STATE OF NORTH CAROLINA
DEPARTMENT OF TRANSPORTATION

September 16, 2013

Subject: **Modification of Section 404 Nationwide Permit 13 and 33 and Section 401 Water Quality Certification** for the proposed replacement of Bridge No. 215 over Mountain Creek on SR 1542 in Stanly County, Federal Aid Project No. BRZ-1542(7), Division 10, TIP No. B-5137, Debit \$240 from WBS 42296.1.1.

PERMIT DRAWING
SHEET 2 OF 7

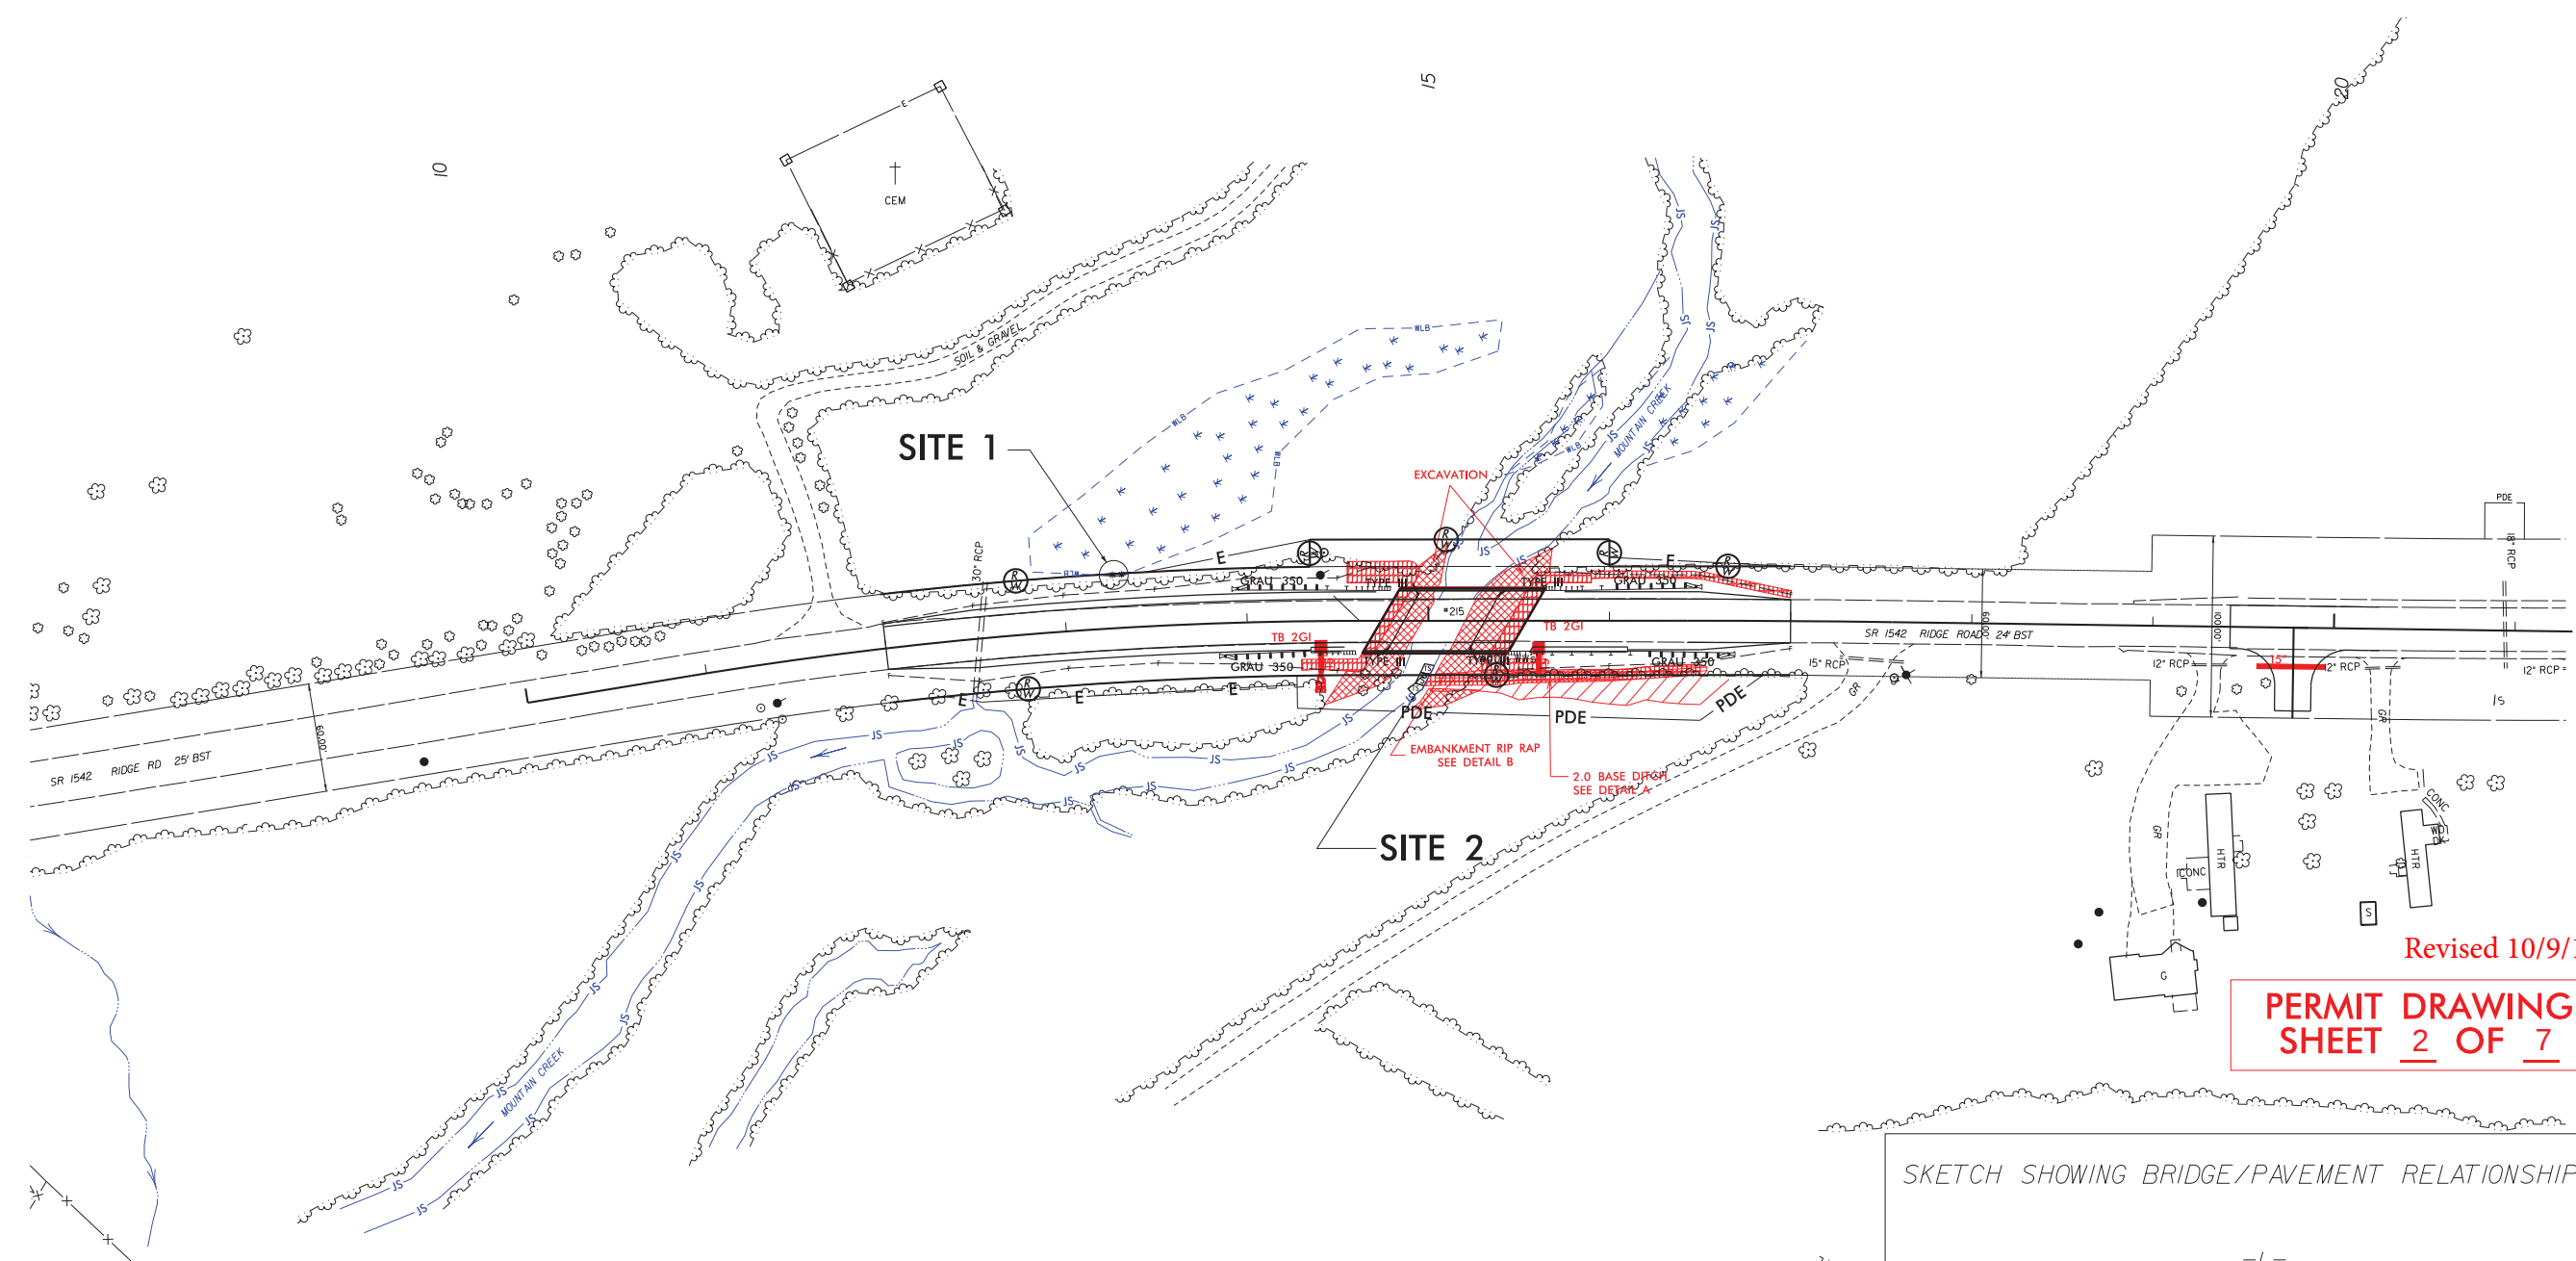
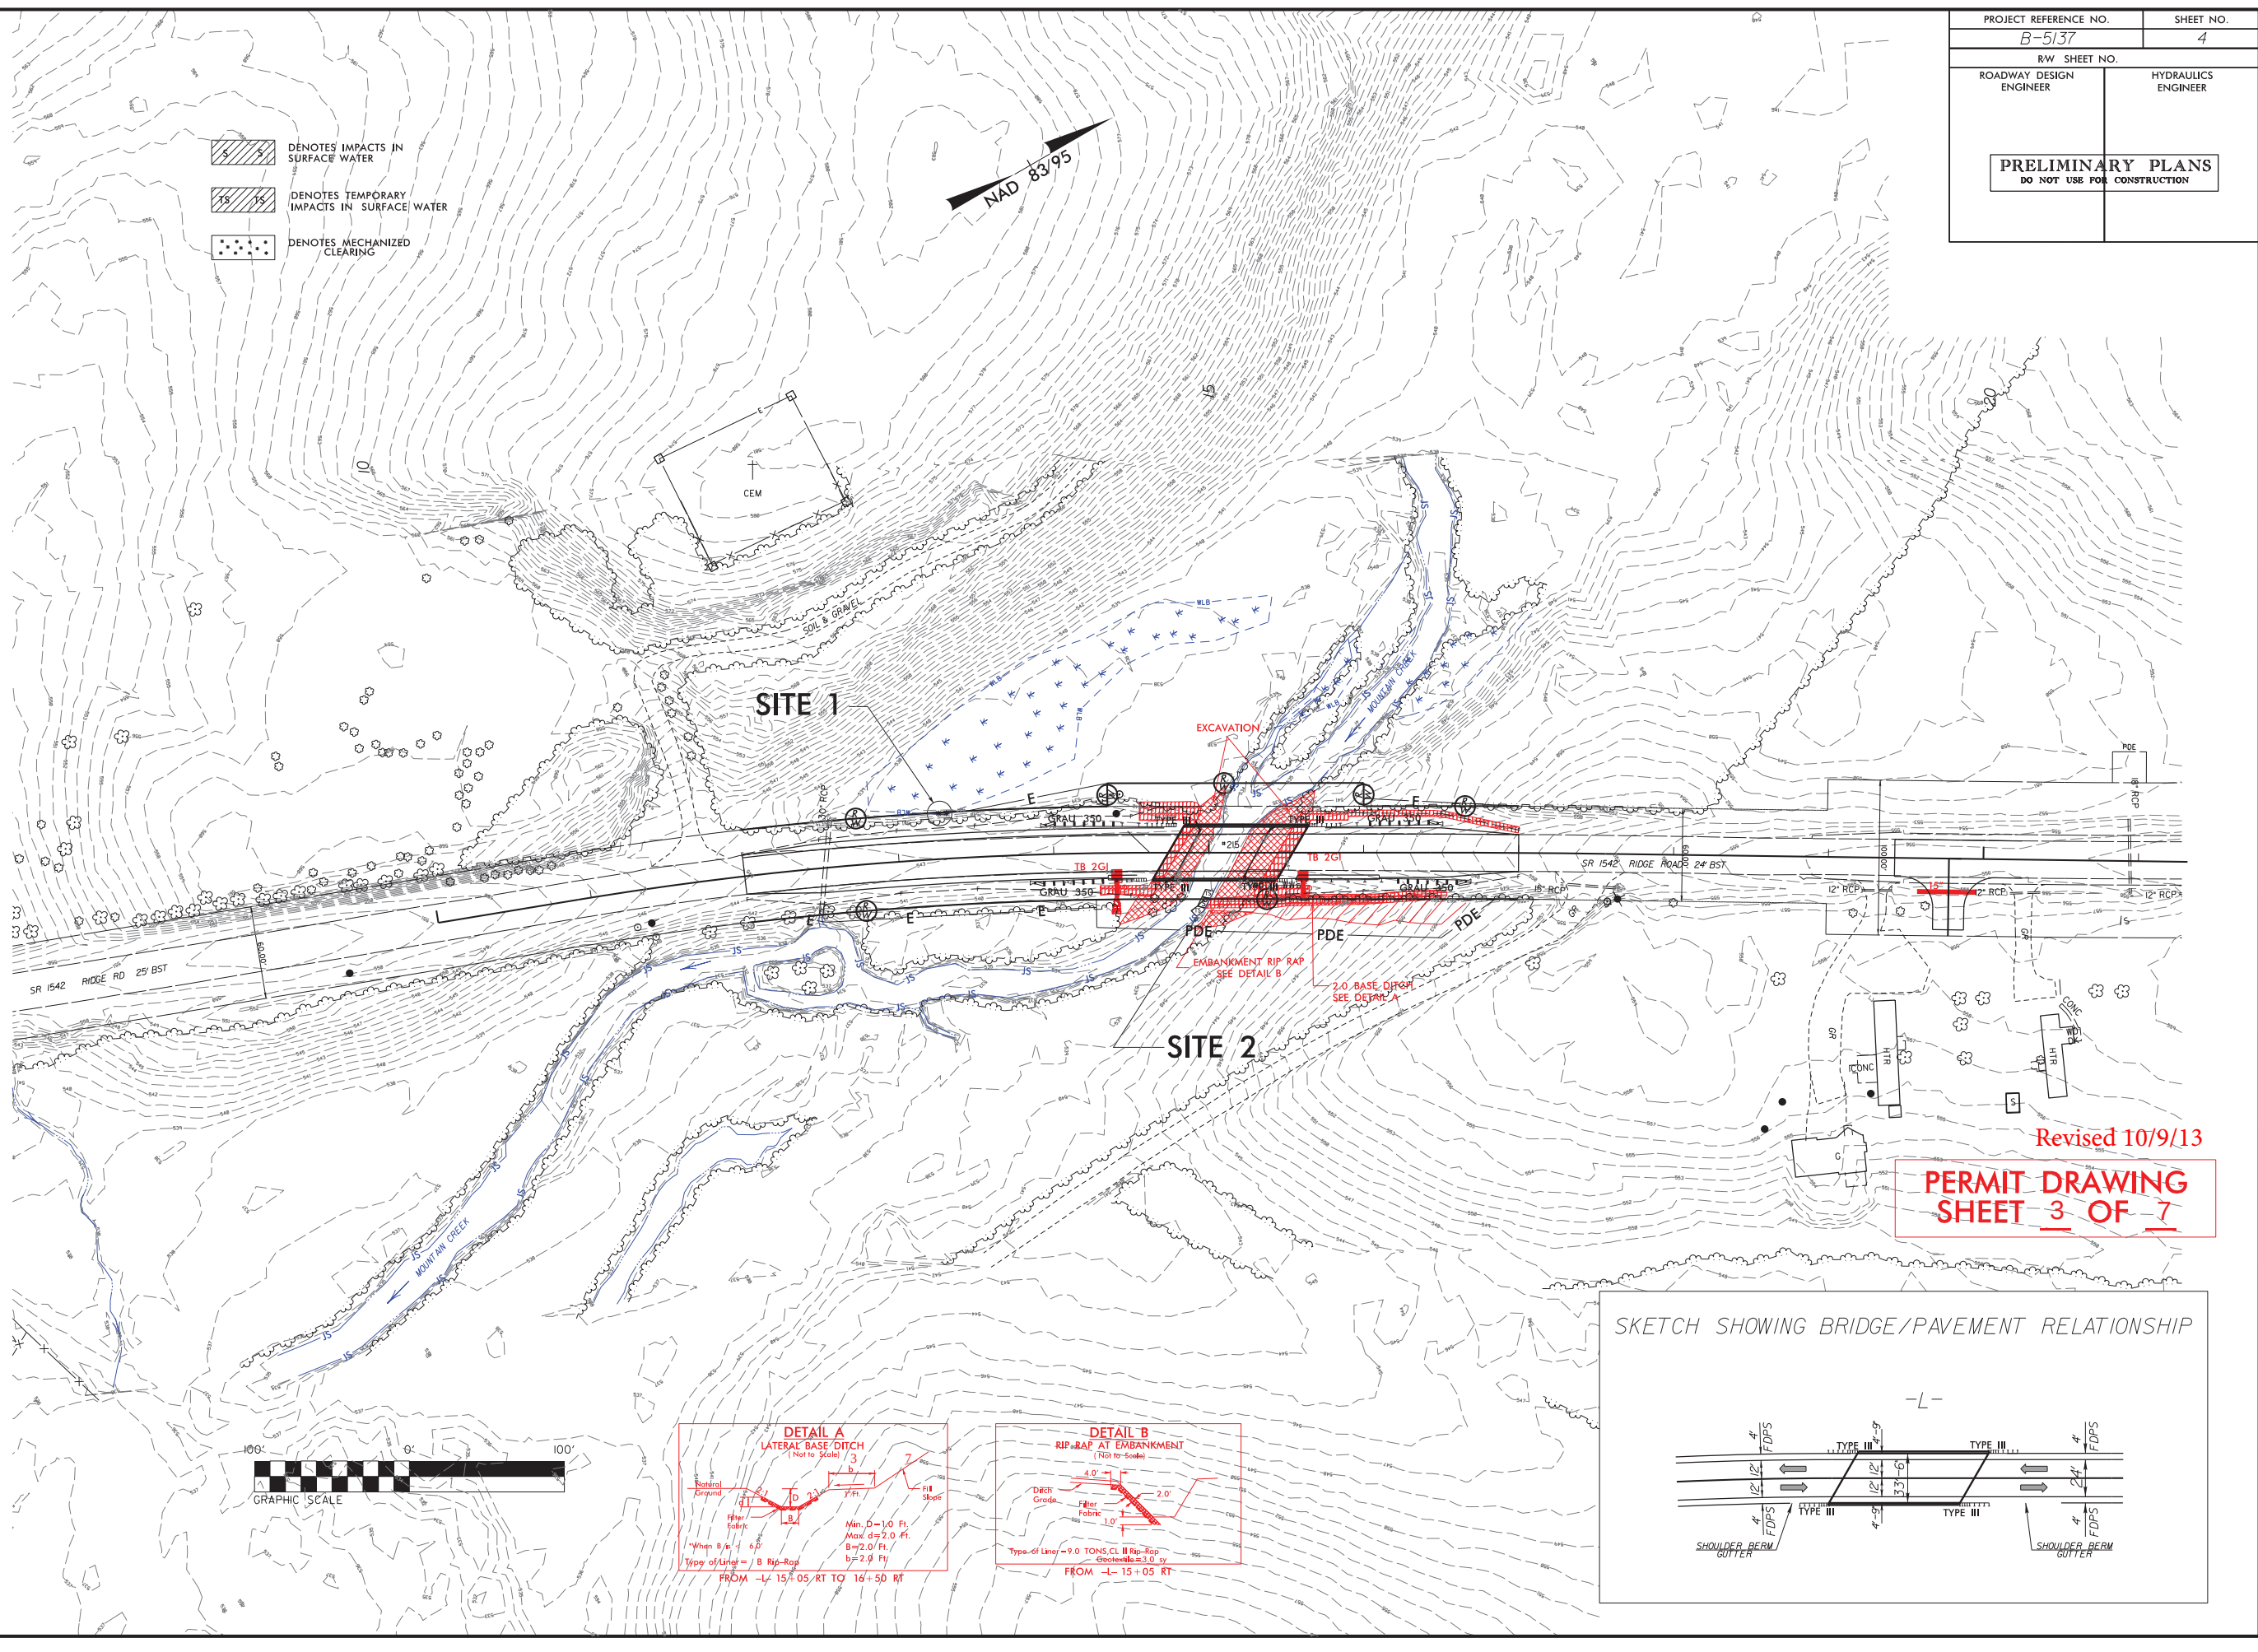
Due to Division concerns regarding the stability of the existing bank under the bridge during the construction of the new eastern bent, the design has been modified to include 70 additional linear feet of bank stabilization in this location. This revised design will preserve the integrity of the channel profile under the bridge during and after construction. It will result in an increase of bank stabilization impacts from 8 to 78 linear feet. It does not constitute loss of water and does not require mitigation.

Due to the increased bank stabilization, a portion of the location of the <0.01 ac (10 linear feet) of temporary impact has been shifted to the north end of the stabilization.
